From: Anita Gardner <Anita.Gardner@arun.gov.uk>
Sent: 08 December 2020 08:48
To: Planning.Responses <Planning.Responses@arun.gov.uk>
Subject: FW: Objection to Planning Application - AB/114/20/PD

Objection to Planning Application
AB/114/20/PD
Riverside House
2 Fitzalan Road
Arundel

BN18 9JS

PROPOSED ROOF PLAN

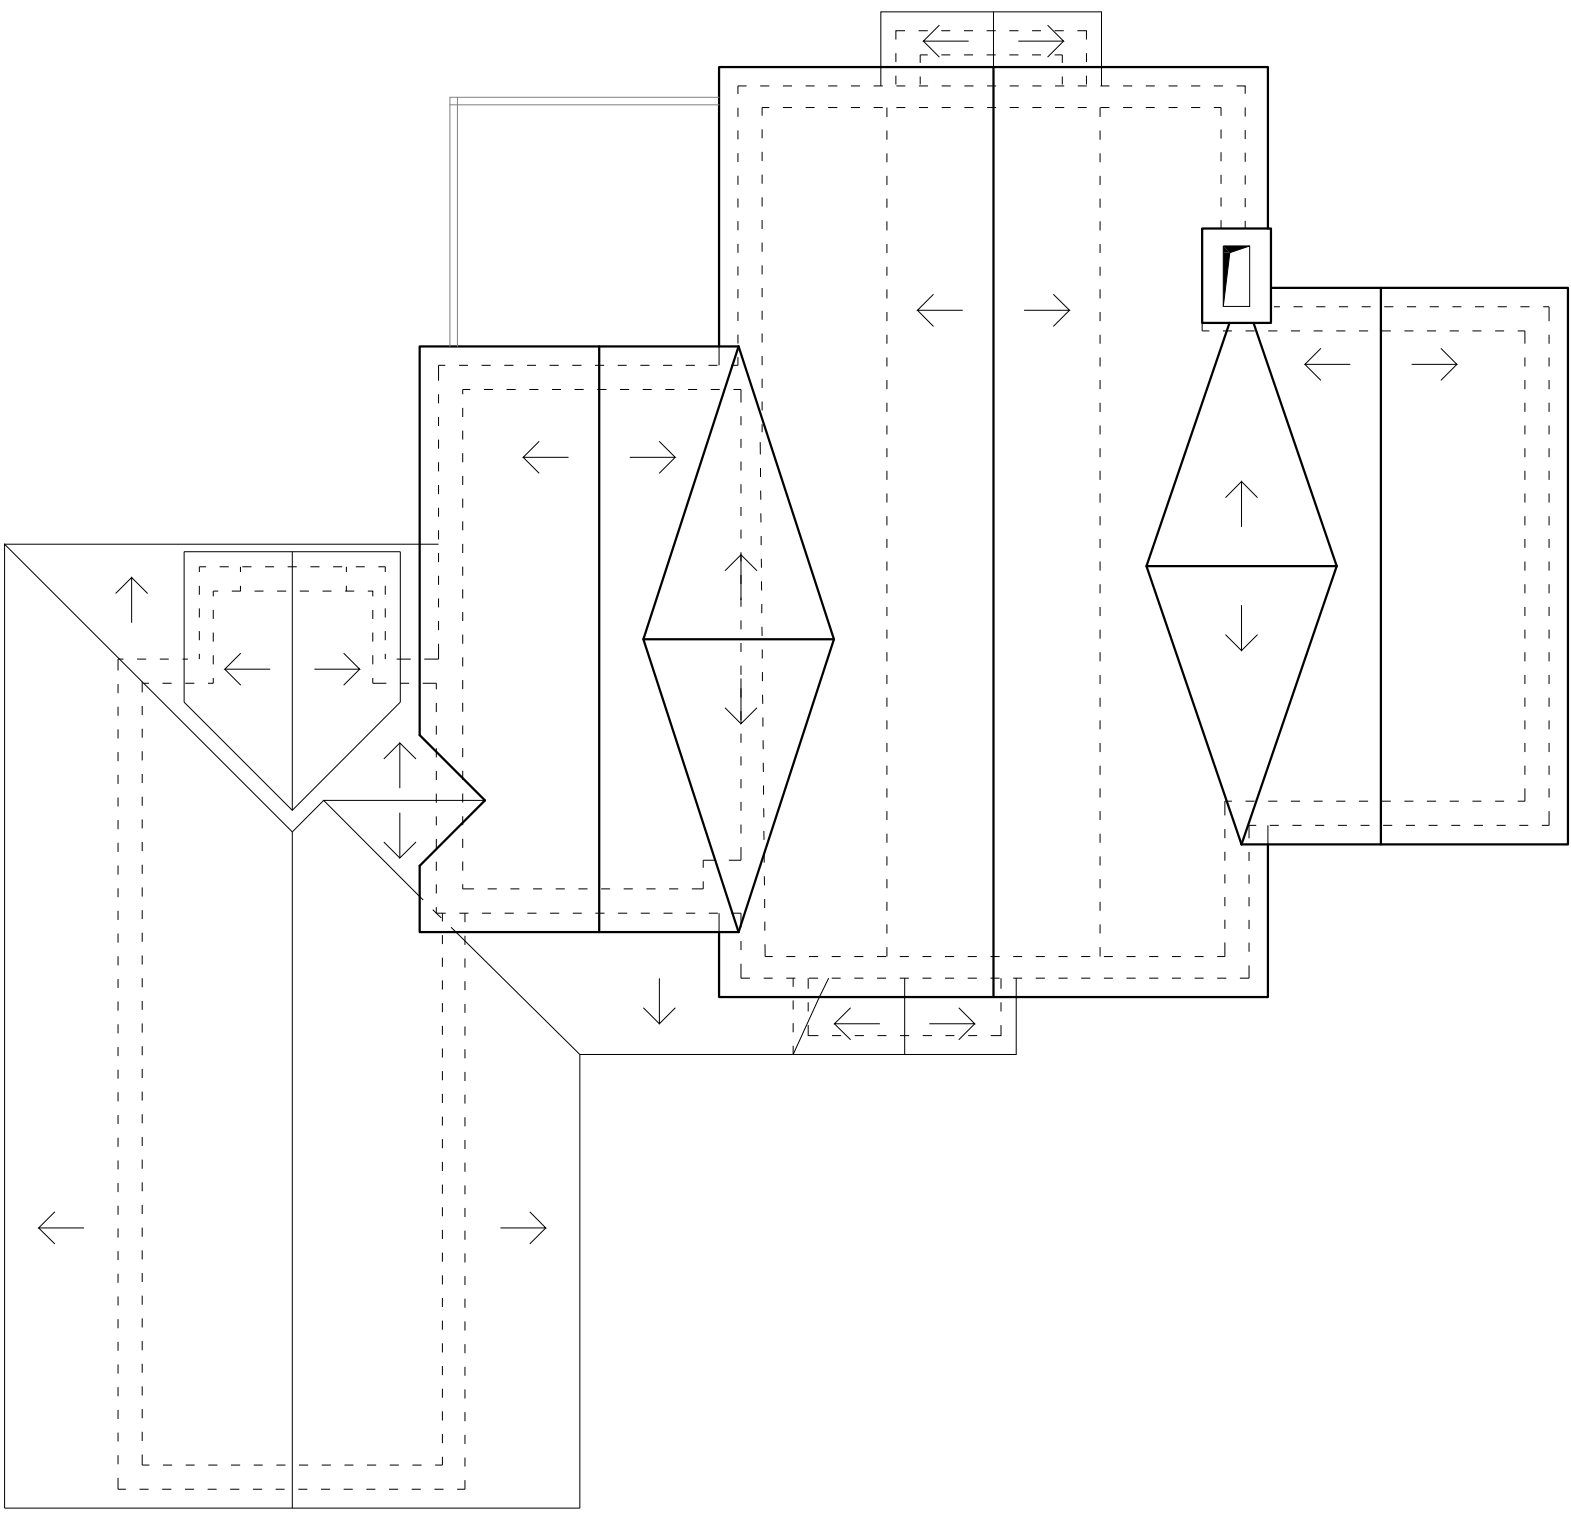
3. The proposed elevation will obscure the view into and out of the Arundel Conservation Area, much to its detriment.
4. I note from the plans that there are some eleven proposed bathrooms, the future intent for which is surely a multi-occupancy dwelling of several flats. If this is indeed the case it should be declared as such, and not become an example of incremental development by stealth. If the intent is for a multi-occupancy building then parking requirements should be appropriately scaled, and the increase in traffic taken into consideration at this stage of the planning application.
